Ribble Valley Borough Council
Housing & Development Control

Application no: **3/2023/1018**

Address: **Peele House Sawley Road Sawley BB7 4LE**

Proposal: **Proposed erection of a single-storey extension to rear; alterations to fenestration; addition of new door openings and internal re-modelling.**

PROPOSED GROUND FLOOR PLAN
Scale 1:50

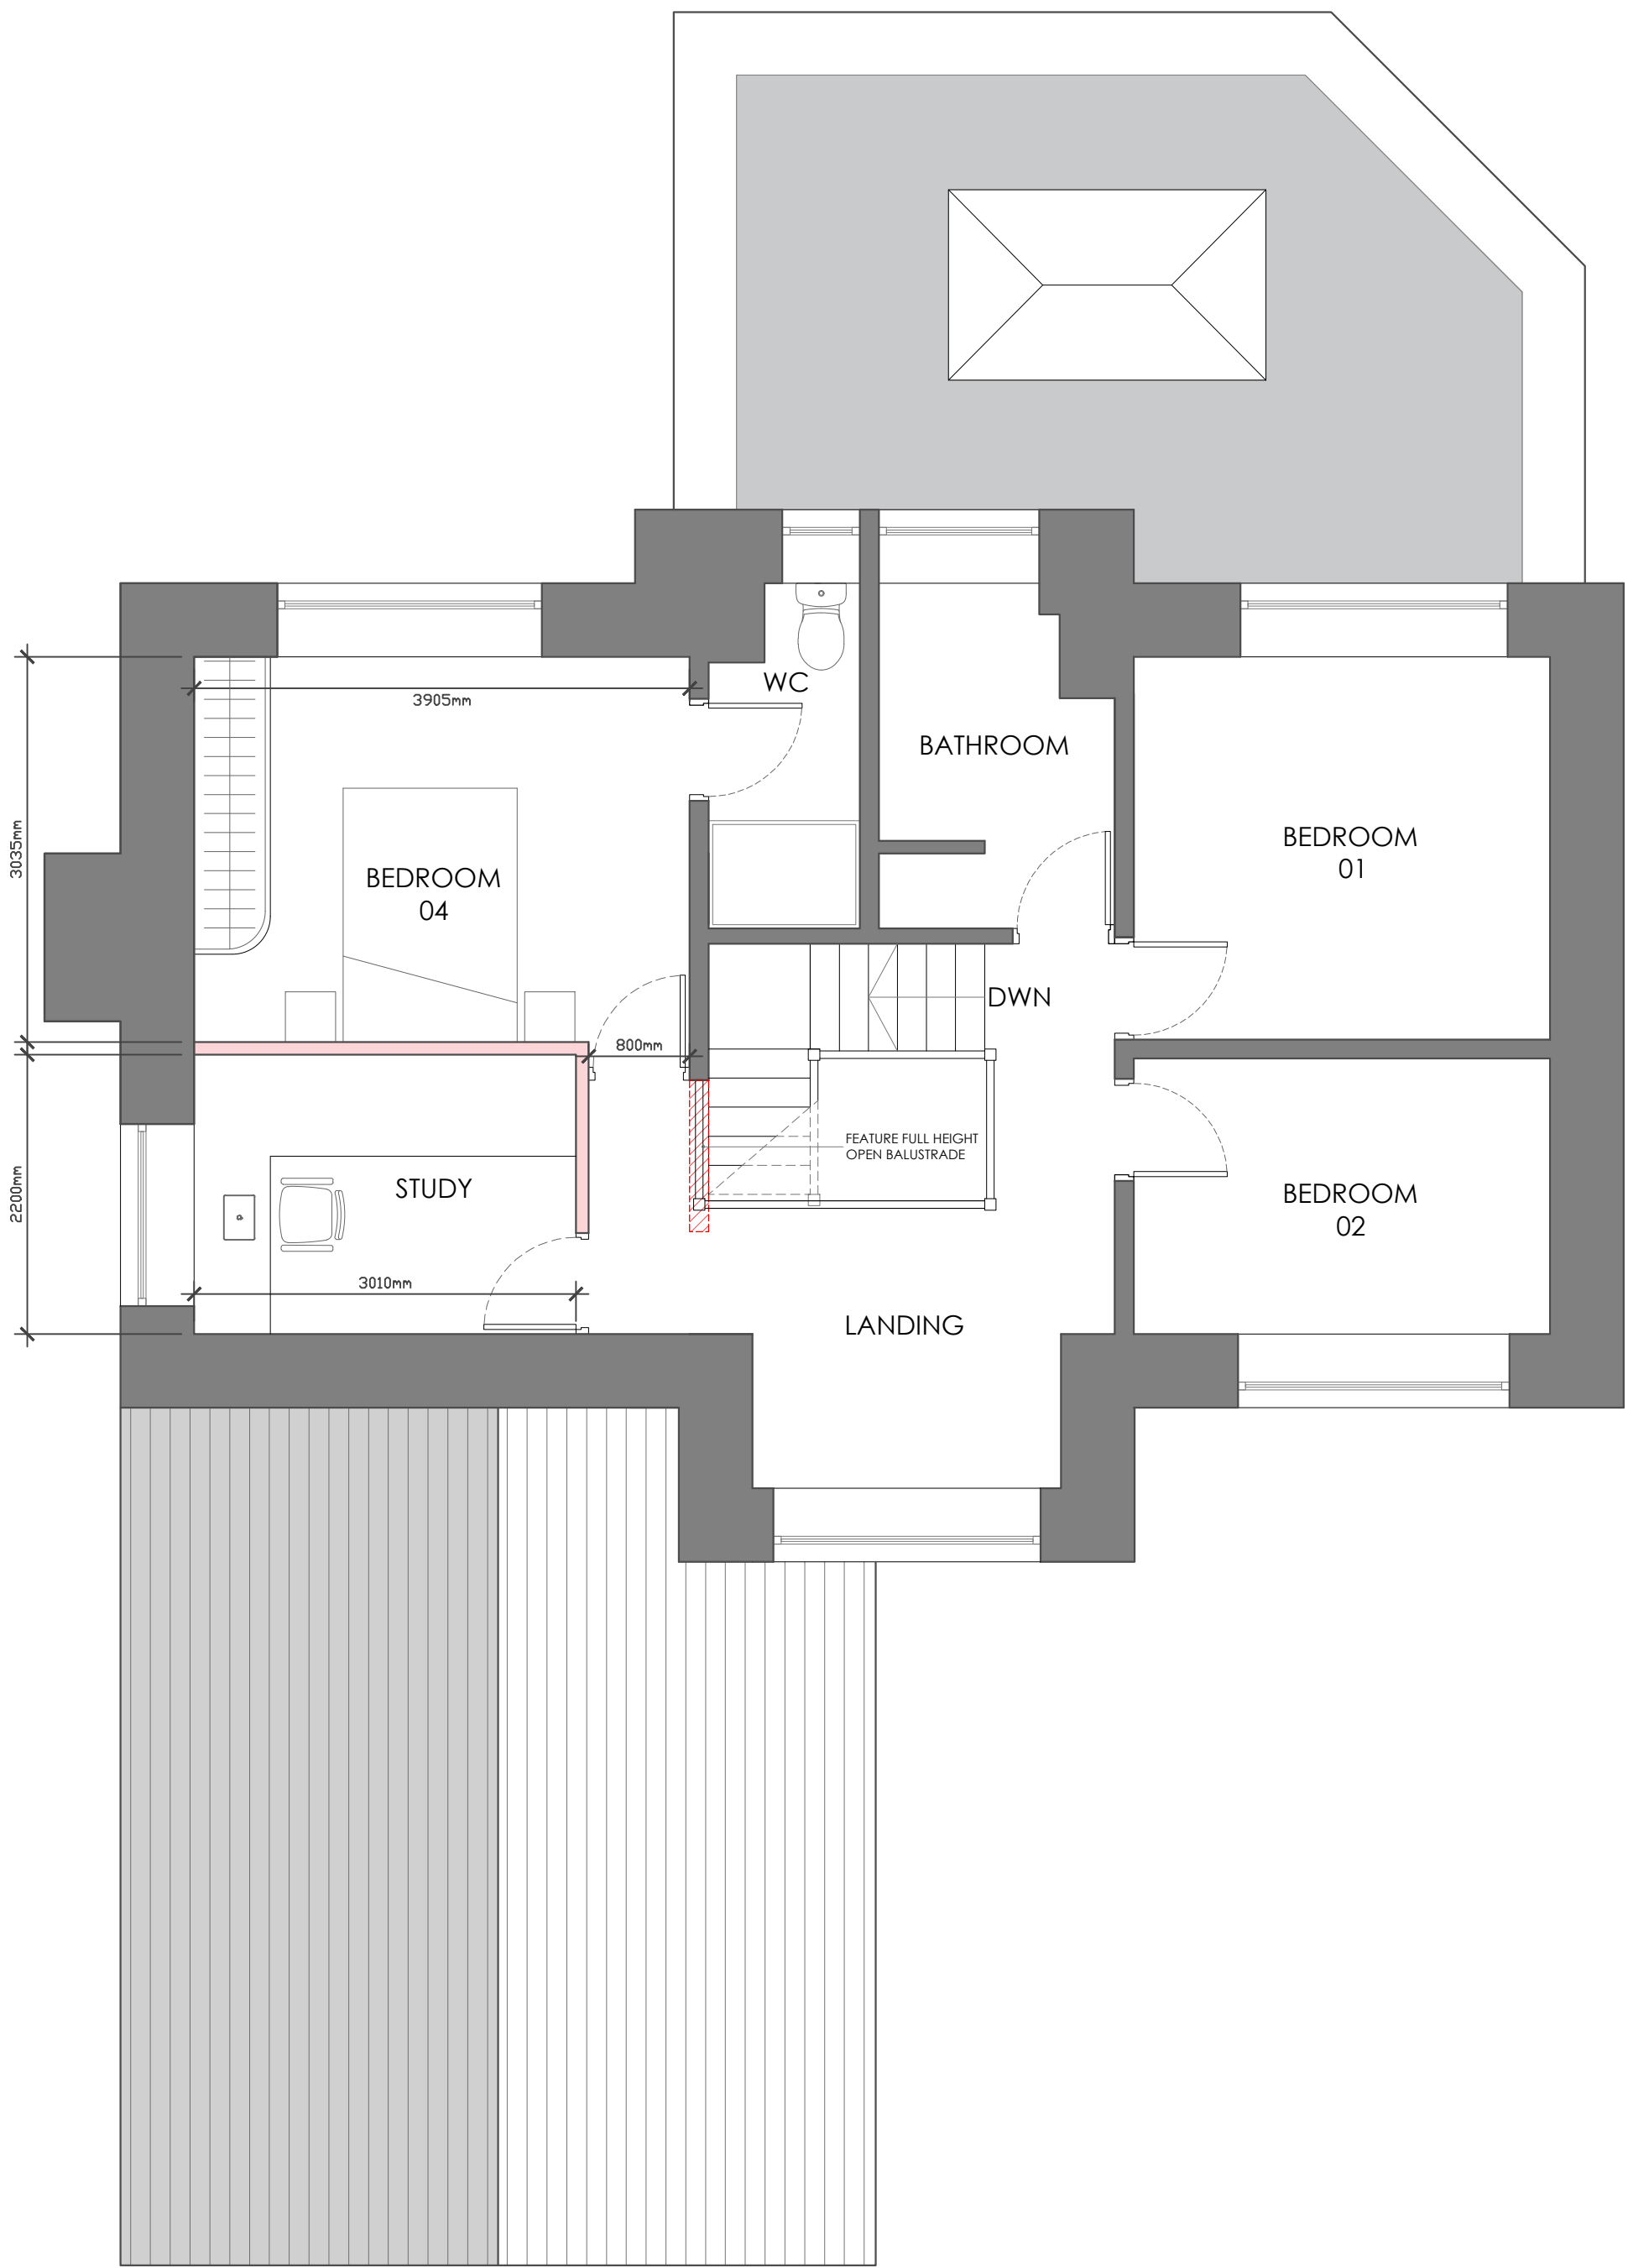
The LHA have reviewed the supporting documents and note that the number of bedrooms at the site will increase from 3 to 4. For the site to comply with the parking standards as defined within the Joint Lancashire Structure Plan, the LHA require 3 car parking spaces to be provided.

However, the site can only provide 2 car parking spaces with the integral garage as shown on SPA drawing number 6608-P04D titled "Single storey rear extension and internal remodelling- Proposed Floor Plans and Elevations" not having the adequate internal dimensions to provide a car parking space with the LHA requiring the garage to be a minimum of 6m x 3m. Therefore, the LHA require a revised plan showing that the site can provide 3 car parking spaces to comply with LHAs parking guidance.
